# CITY OF ALBUQUERQUE

**RE: Trails Unit 3A DMP Ponds  
Valle Prado Units 1&2 (File: C09D011W)  
Grading Plan, Engineer's Stamp Date 9-16-2014**

Based upon the information provided in your submittals received 9-16-14, the above referenced plan is approved for Grading Permit with the following condition:

CITY OF ALBUQUERQUE	
		PUBLIC WORKS DEPARTMENT	
TRAILS UNIT 3A DMP PONDS			
POND D1			
GRADING PLAN			
Design Review Committee	City Engineer Approval	Mo./Day/Yr.	Mo./Day/Yr.
City Project No.	Zone Map No.	Sheet	Of
XXXXXX	C-09-Z	2	5

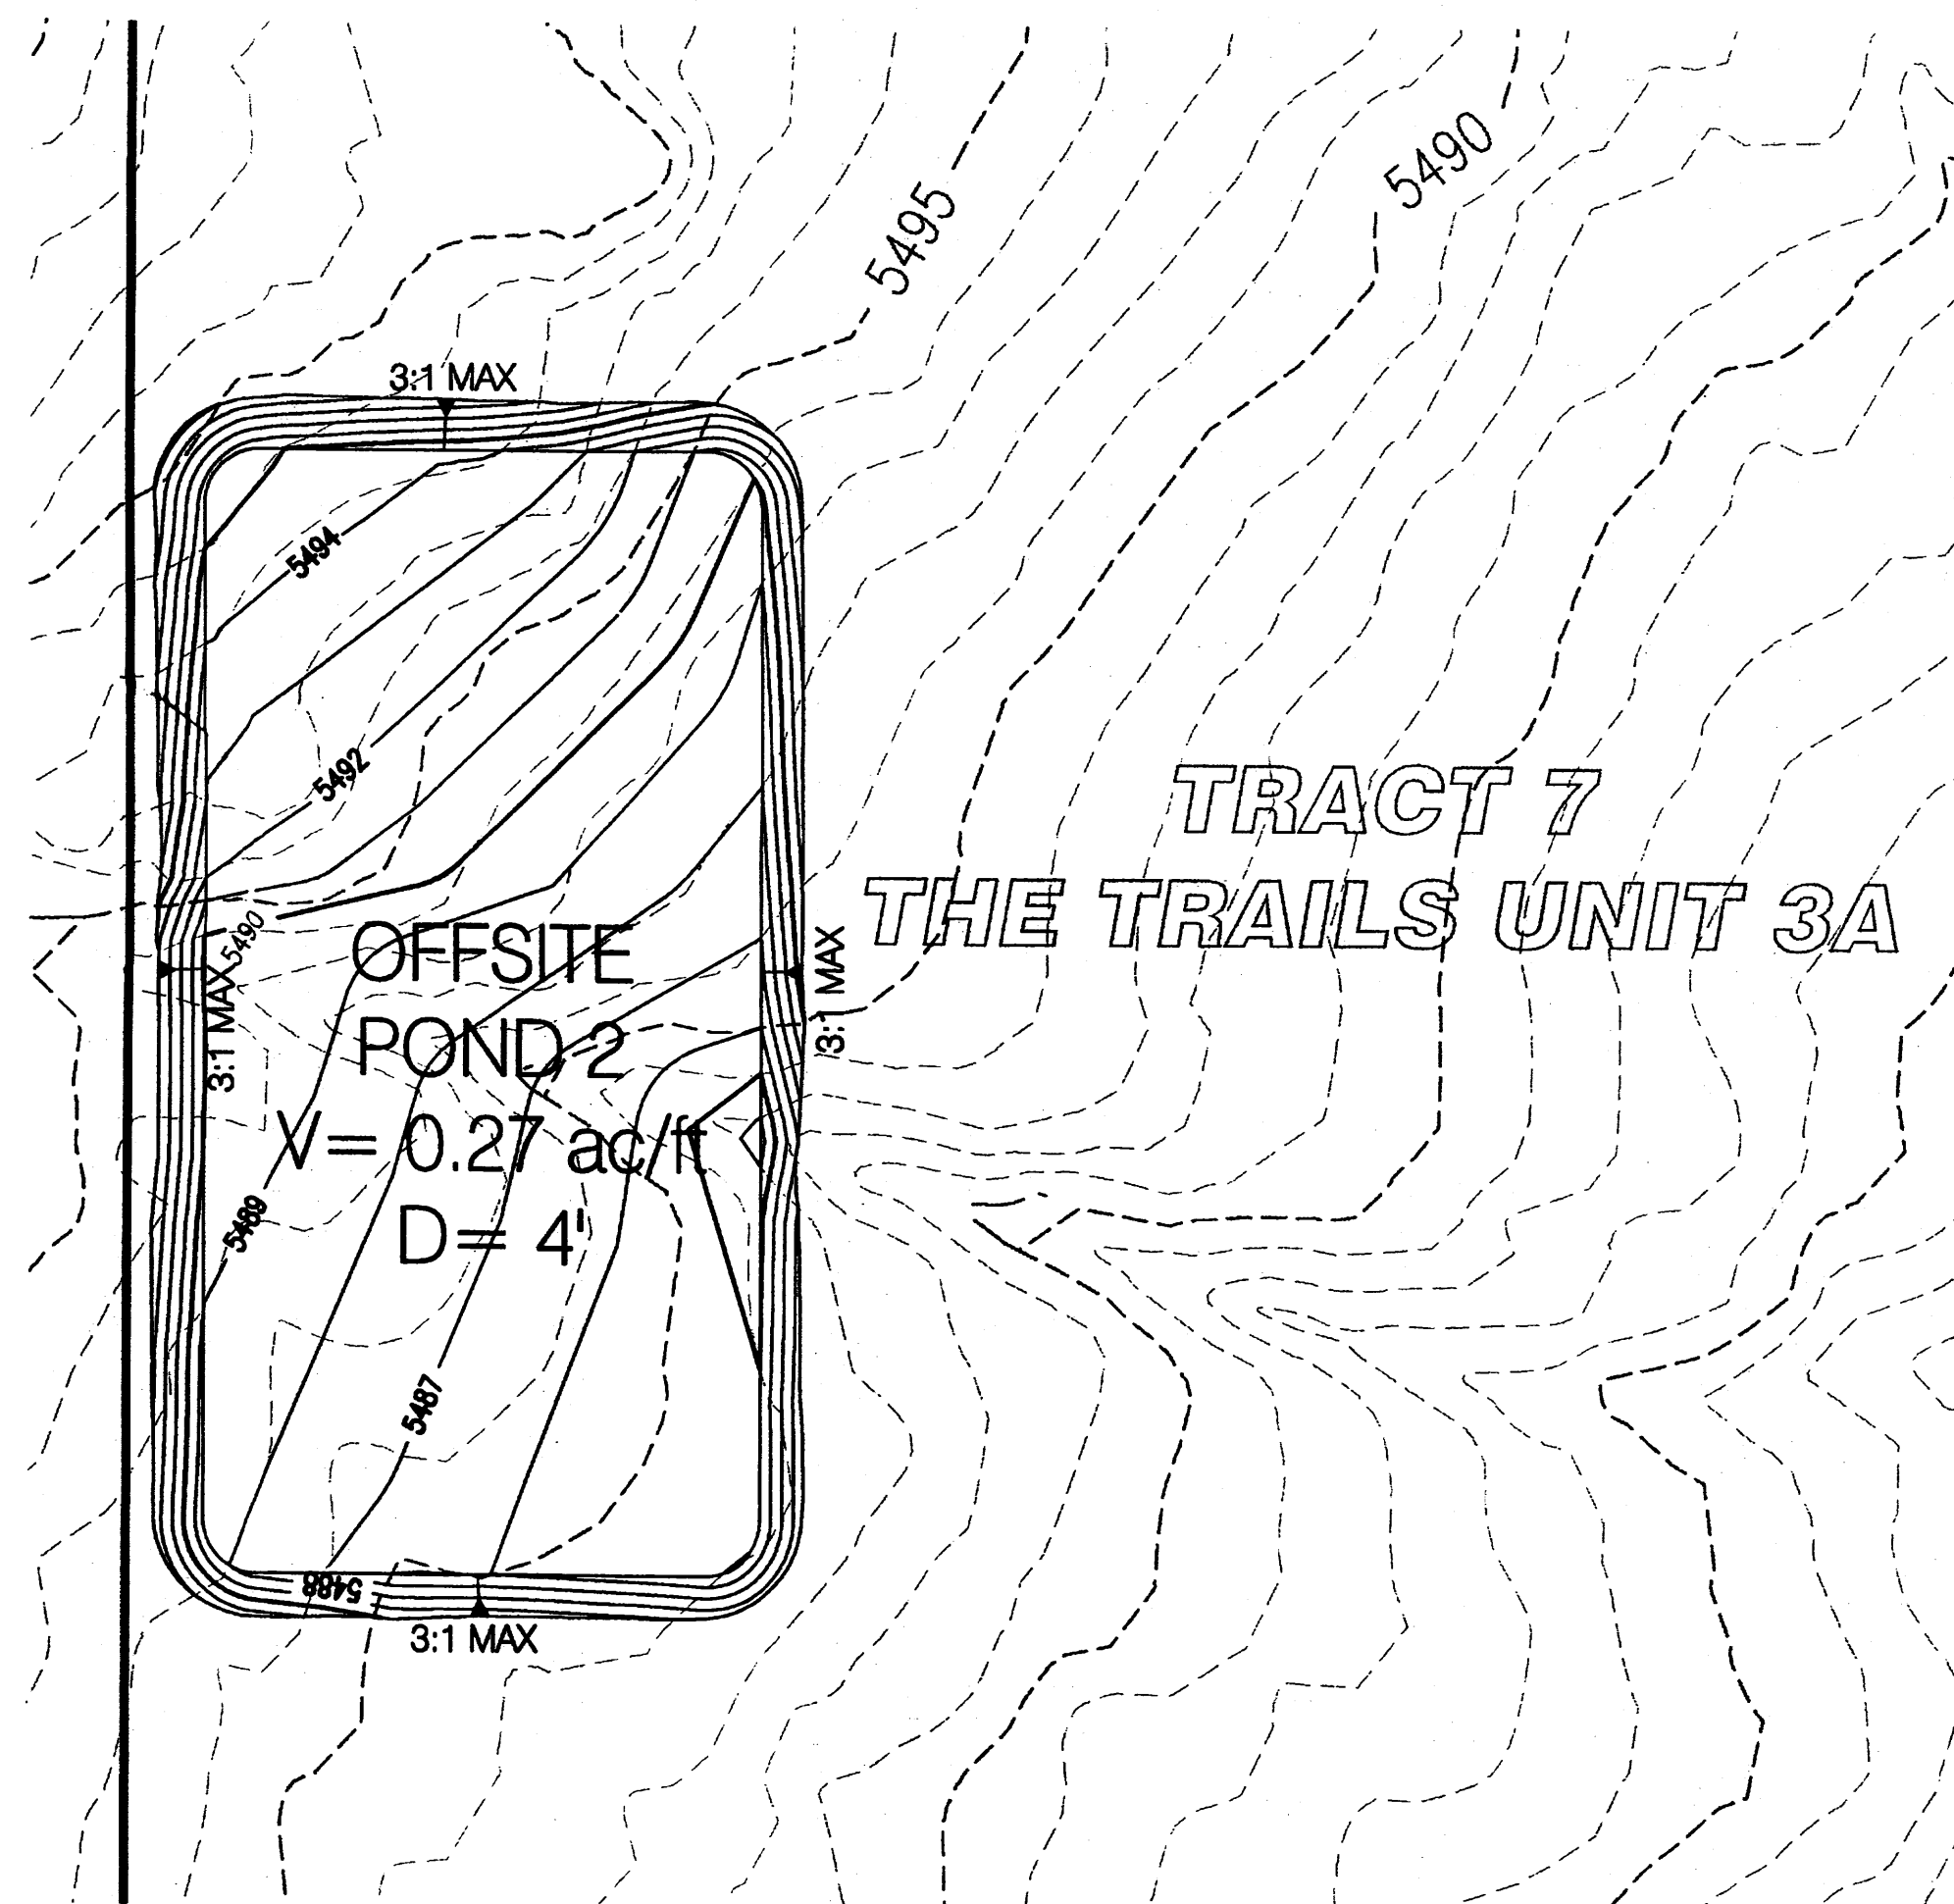
- 1) Detailed design of standpipe in Pond D1 will be submitted after the pond is graded, and will be designed per as-built condition.
